26 August 2021
Ref: 20-17 2019/005574

SafeWork recommendations Orica Kooragang Island – Mod 5 (MP08_0129-Mod-5)

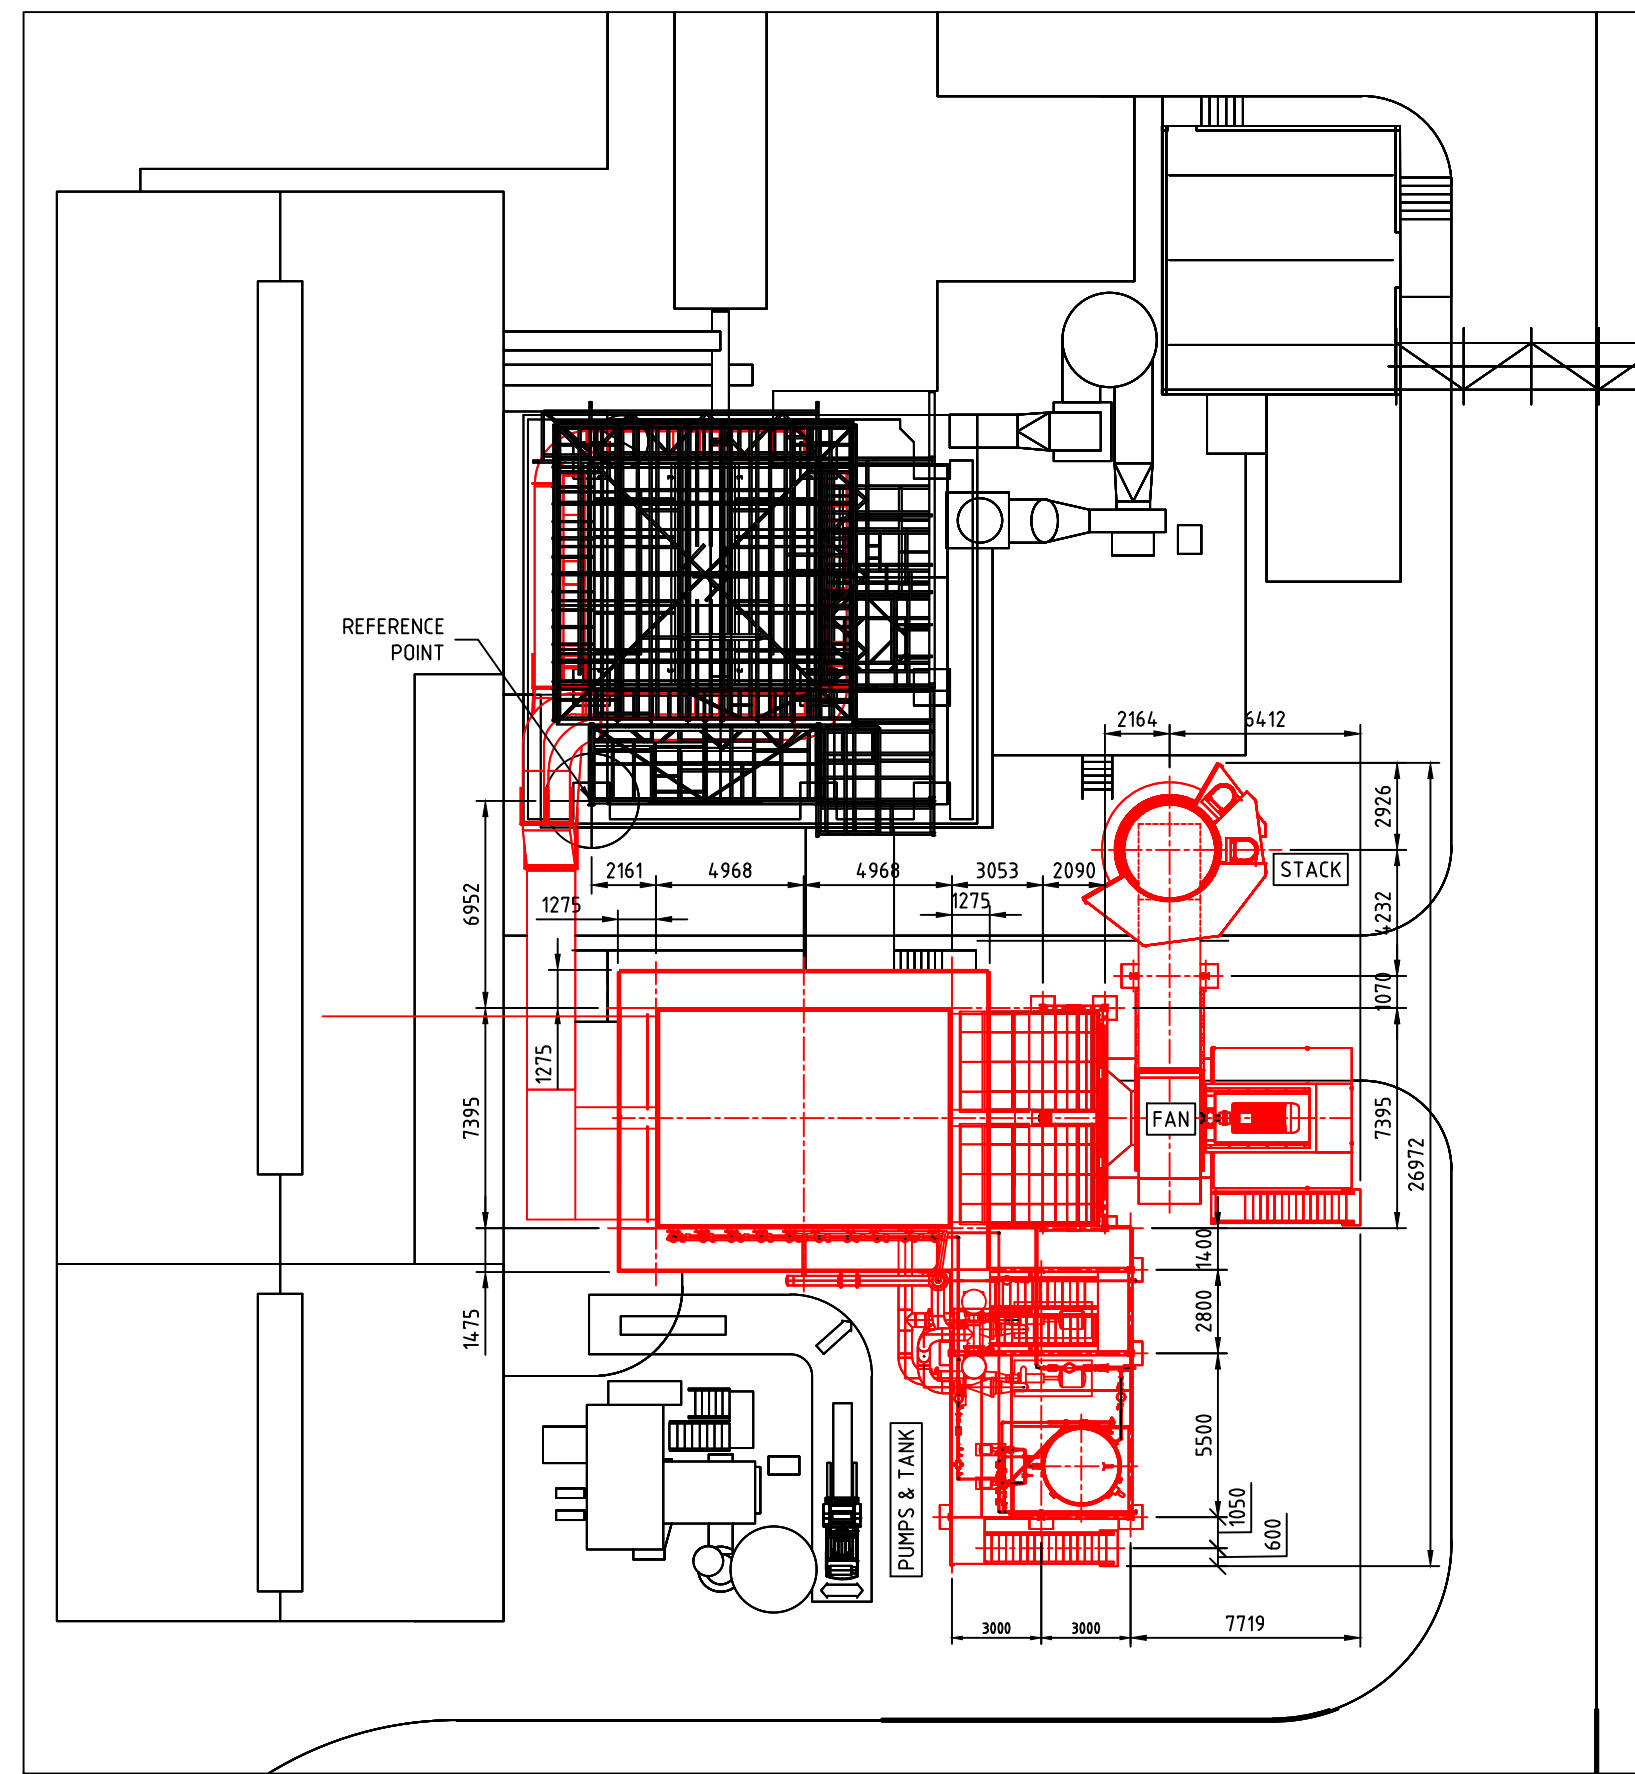
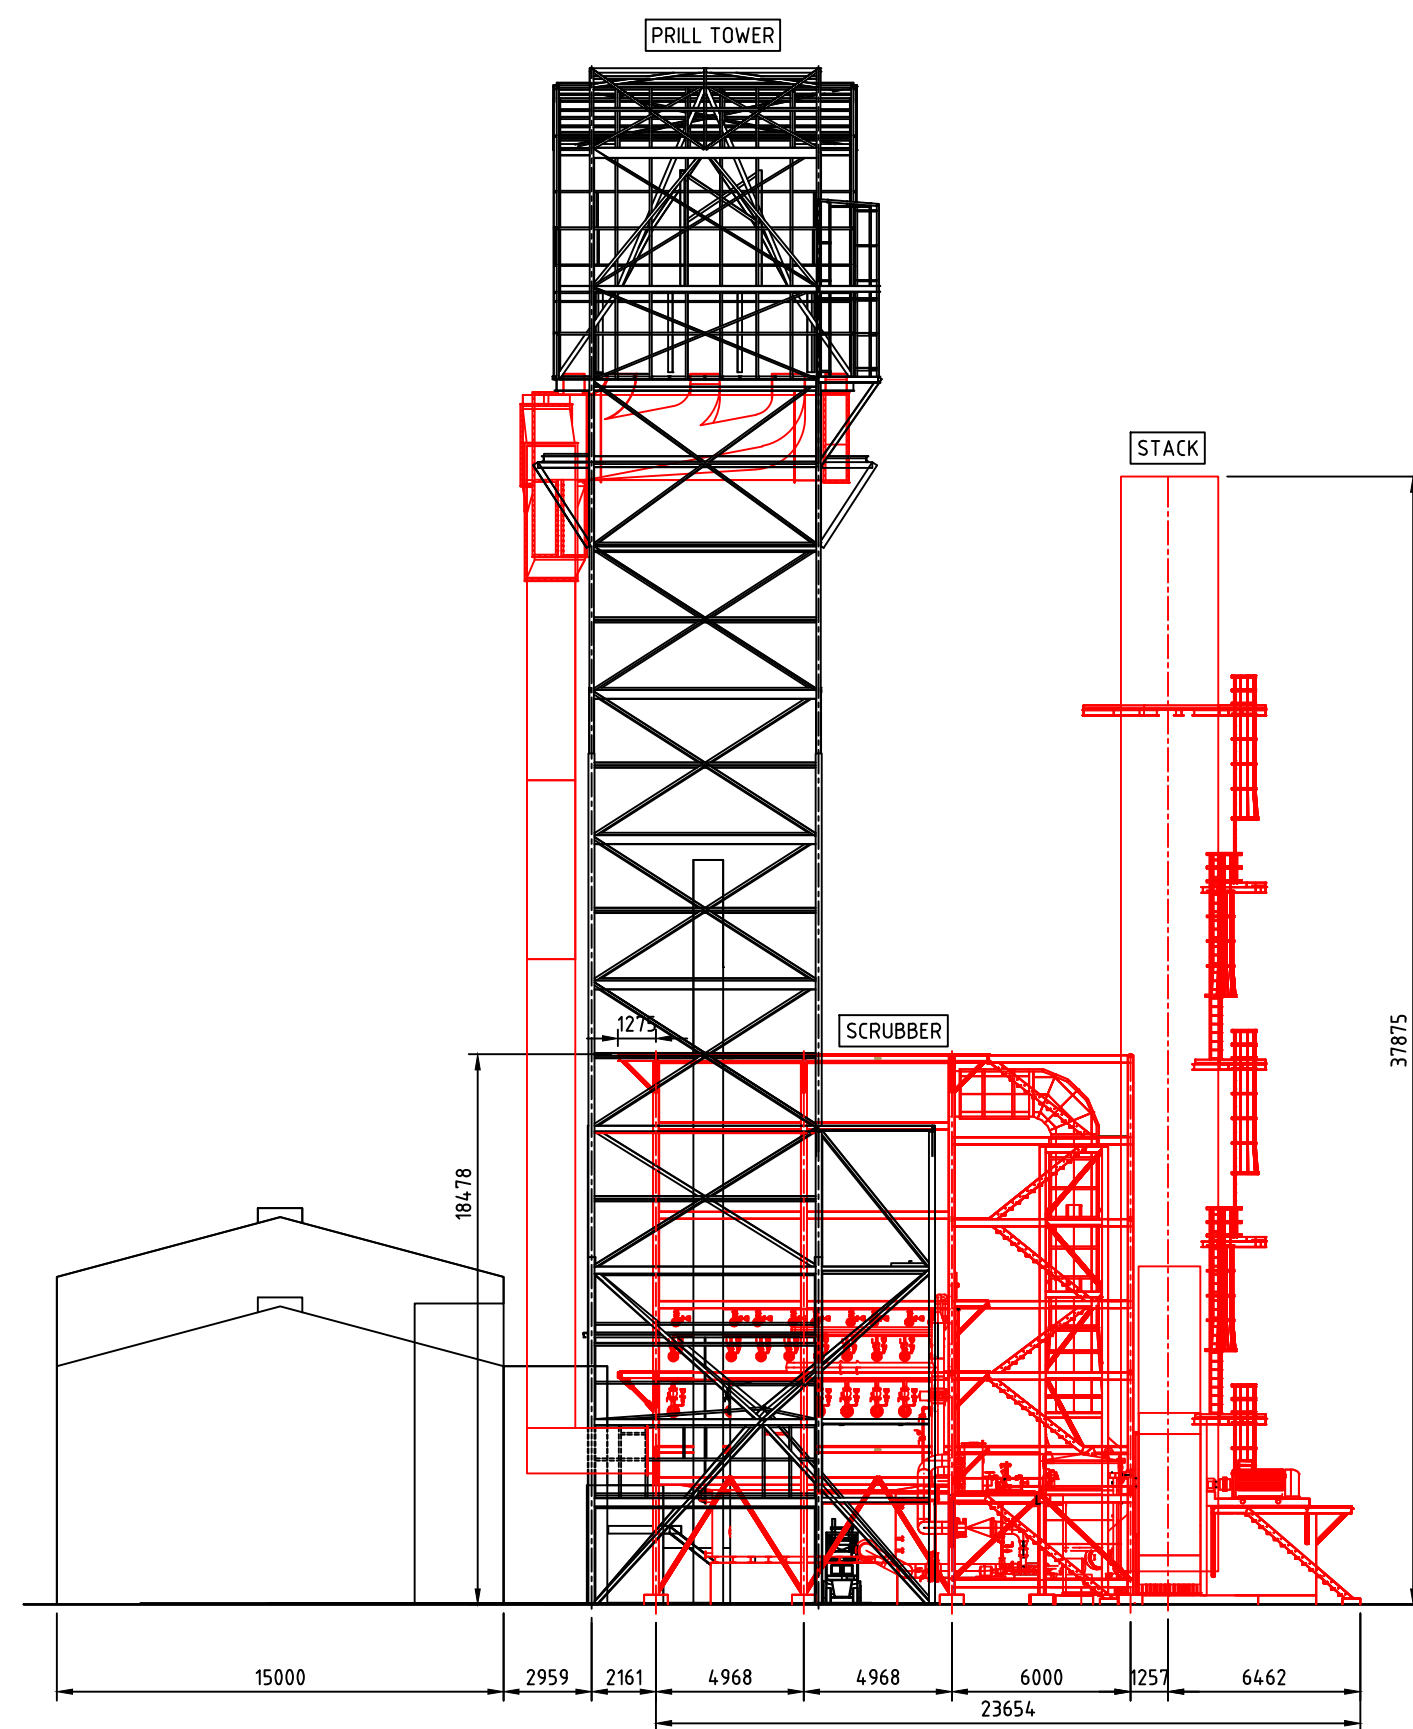
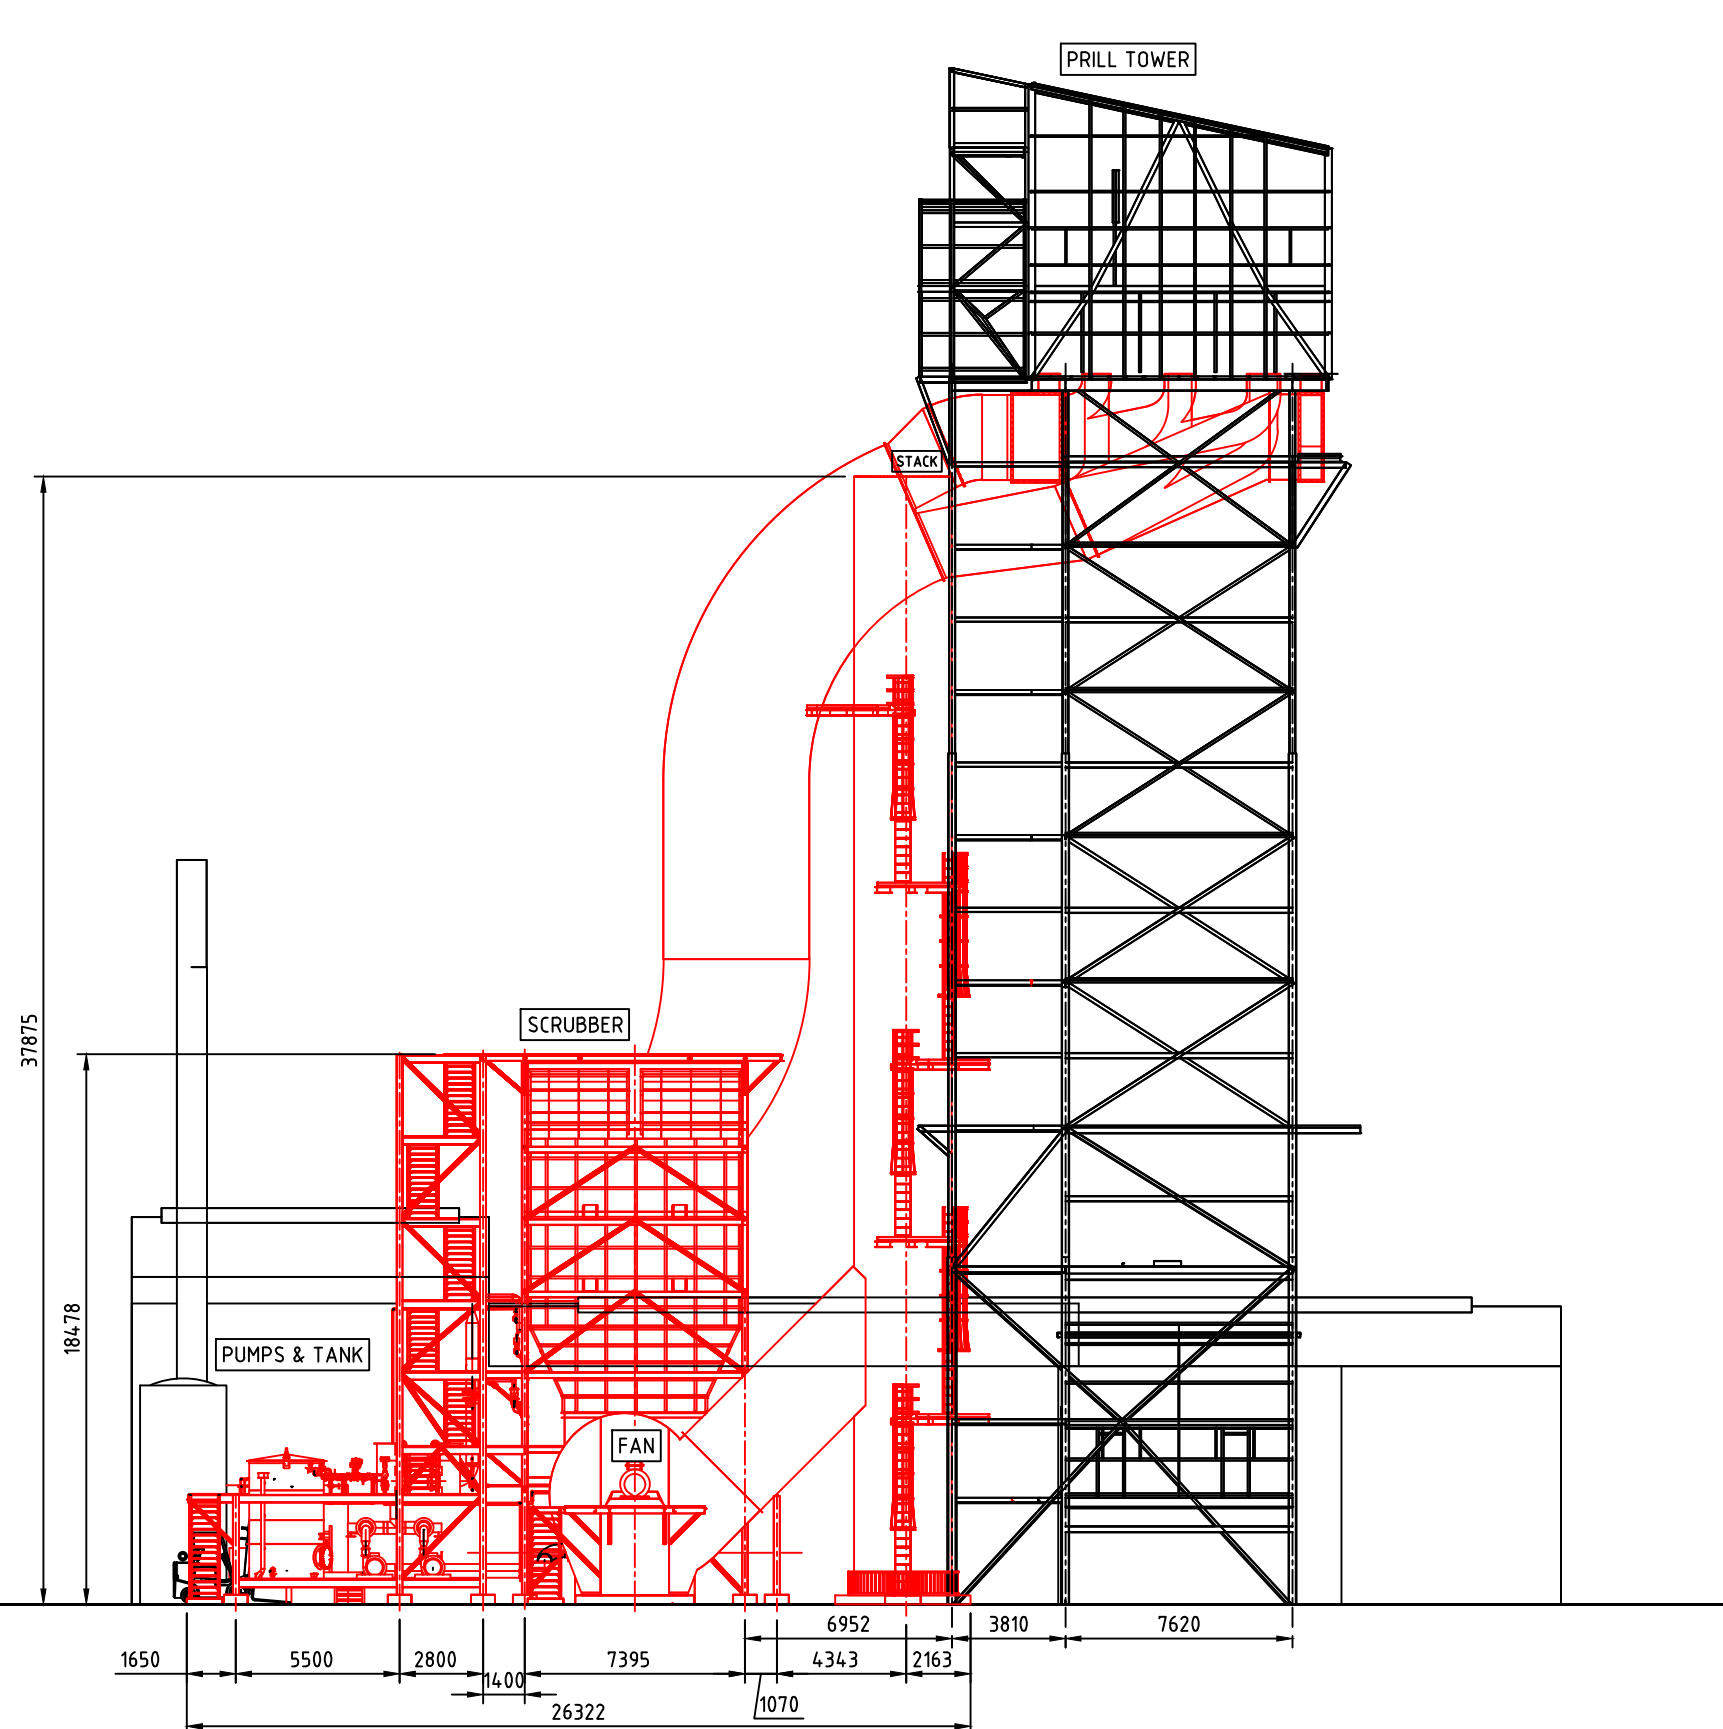
1. Request Orica perform hazard identification and risk assessment for construction activities.
2. Request Orica pay special attention to overhead crane use and ensure any crane failure does not impact ammonium nitrate store or ammonia storage tank integrity.
3. Request Orica ensure any construction activities do not compromise housekeeping in the ammonium nitrate store, with special attention to: dust accumulation in AN store, oil leak from vehicles, other machinery result in contaminating AN store
